Recommendation Report for Planning Permission for Works or Extension to a Dwelling

REF NO: EP/11/26/HH

LOCATION: 6 Fairlands
East Preston
BN16 1LH

PROPOSAL: Retrospective application for fence.

3 Proposed (modifies existing) Block Plan
1:500

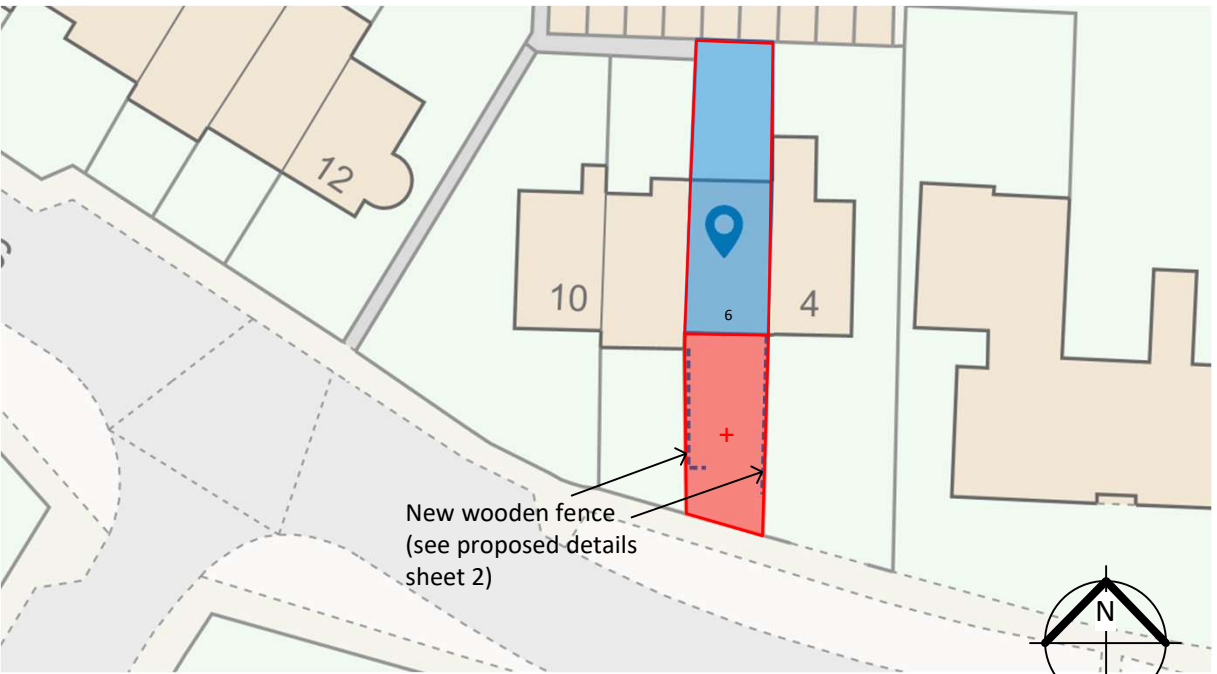
The proposal seeks retrospective planning permission for the installation of a fence to the eastern and western side boundaries to the application site frontage, with a short return to the south west. The western side boundary measures approximately 8.2m in length and the eastern side boundary approximately 10.9m. Due to the sloping nature of the front garden, the height of the fence varies from approximately 1.3m at its lowest point nearest the dwelling, rising to approximately 1.9m towards to the highway. In addition, a side panel facing the highway adjoins the western end of the existing fence, measuring 1.8m in height and 1.2m in width. The fence comprises contemporary horizontal "hit and miss" slatted panels with powder-coated galvanised steel posts finished in anthracite grey.

Retrospective Planning Application: 6 Fairlands			
	Proposed (modification of existing) and Existing – Plan and Elevation			
DRAWN: MGE	SIZE A2	APPLICATION NO EP/11/26/HH	DWG NO 2601-EAD-002	REV 3
DATE: 19/02/2026	SCALE 1:100	SHEET 2 OF 5

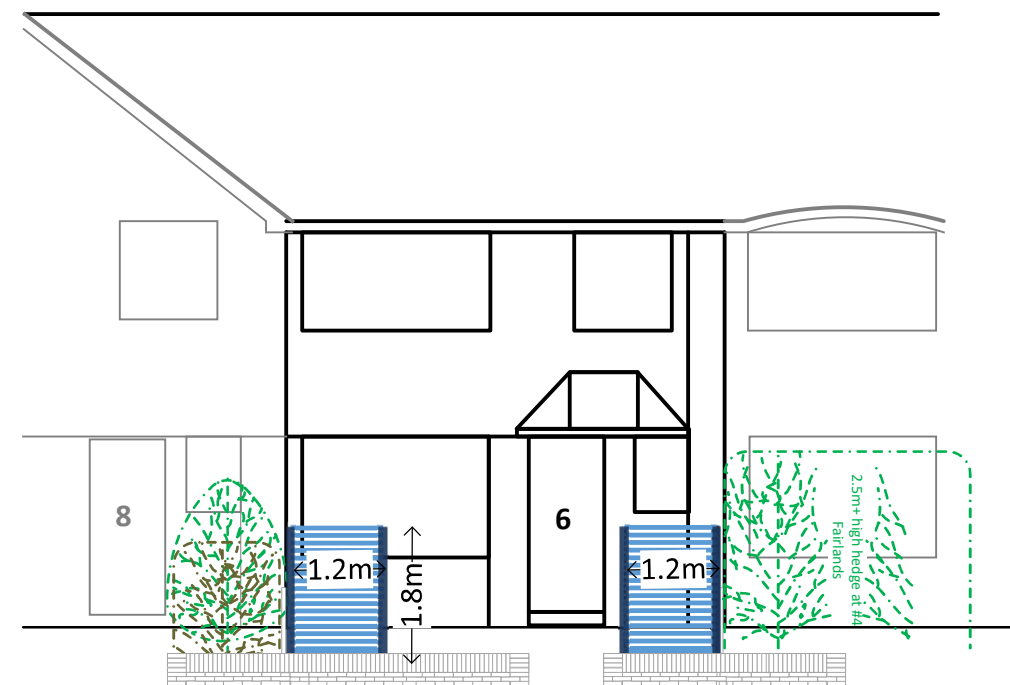
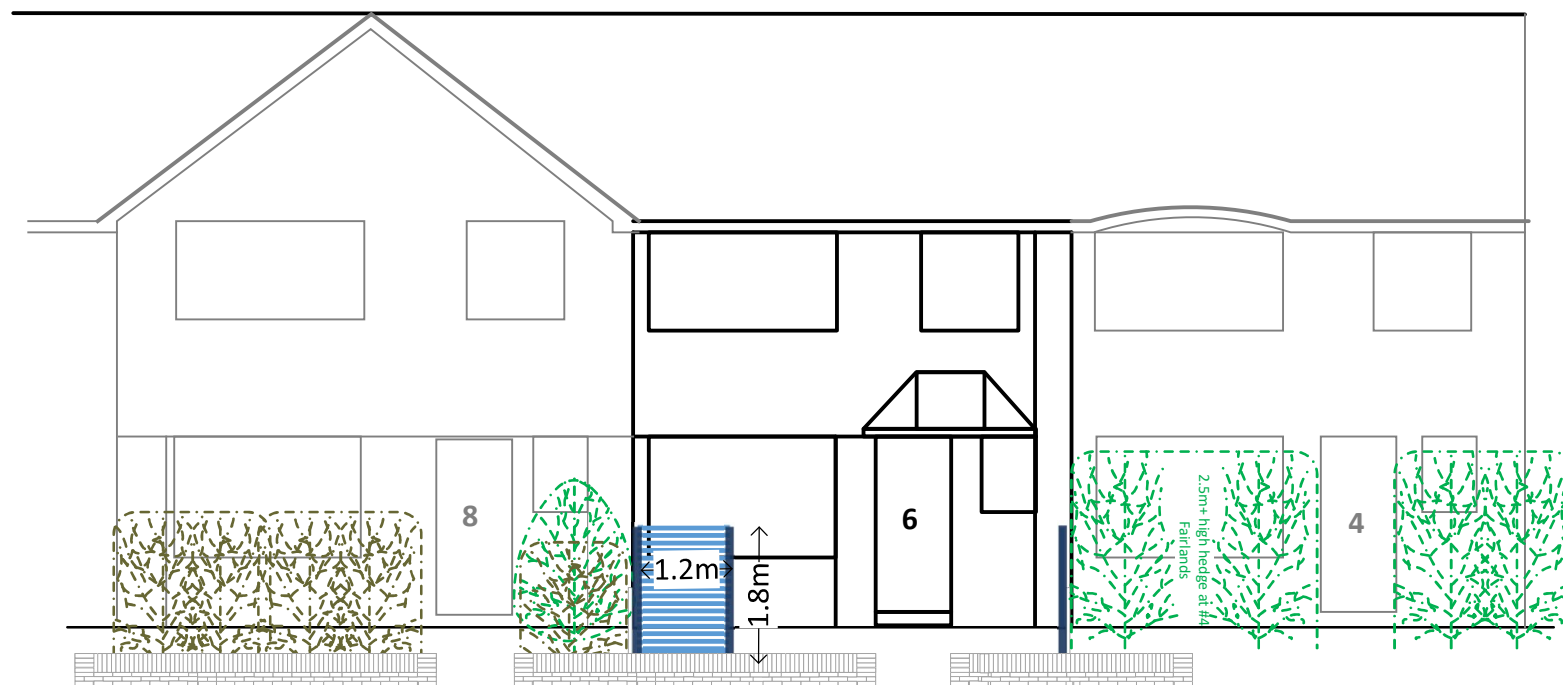
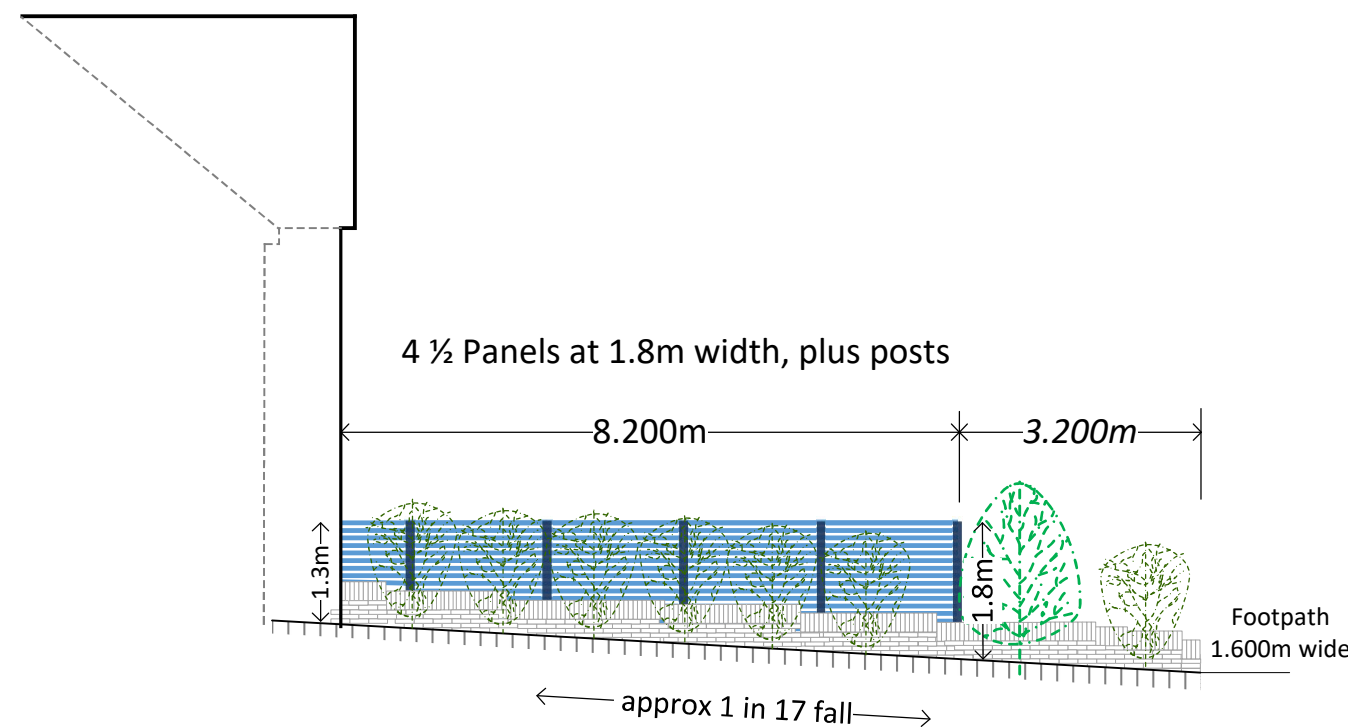
The fencing is highly prominent within the street scene, and the introduction of this form of boundary treatment has resulted in an incongruous and discordant feature that fails to reflect the established open character of the locality. While parts of the fence have been removed prior to the submission of this application, and further reductions are proposed within this application, the remaining structure continues to appear visually dominant and at odds with the prevailing open plan layout of the street scene. Its alien appearance introduces a sense of enclosure uncharacteristic of Fairlands, where open landscaped frontages form a key visual attribute.

The front amenity space is predominantly hard surfaced with limited planting. Part H of the Arun Design Guide (ADG) states that boundary treatments should reflect or enhance existing high quality treatments within the area, noting that close board or panel fencing may not be appropriate. The current proposal conflicts with this guidance, as it does not integrate positively with the established streetscape.

boundary treatments enclosing frontages are not characteristic of the street scene. The fencing within the application site appears visually intrusive and fails to respect or enhance the character of the area in terms of its siting, landscaping or its impact on the open nature of the area. The fencing appears out of keeping with the prevailing pattern of development and has resulted in harm to the character and appearance of the locality. The proposal therefore conflicts with Arun Local Plan policy D DM1, which requires development to contribute positively to local character and the quality of the built environment.

- 1 The side and front boundary fencing, by reason of its height, design and siting, forms an incongruous and visually prominent feature within the street scene. The development fails to respect or preserve the established open character of the area, which is maintained through the original open plan condition restricting boundary treatments. The fencing appears out of
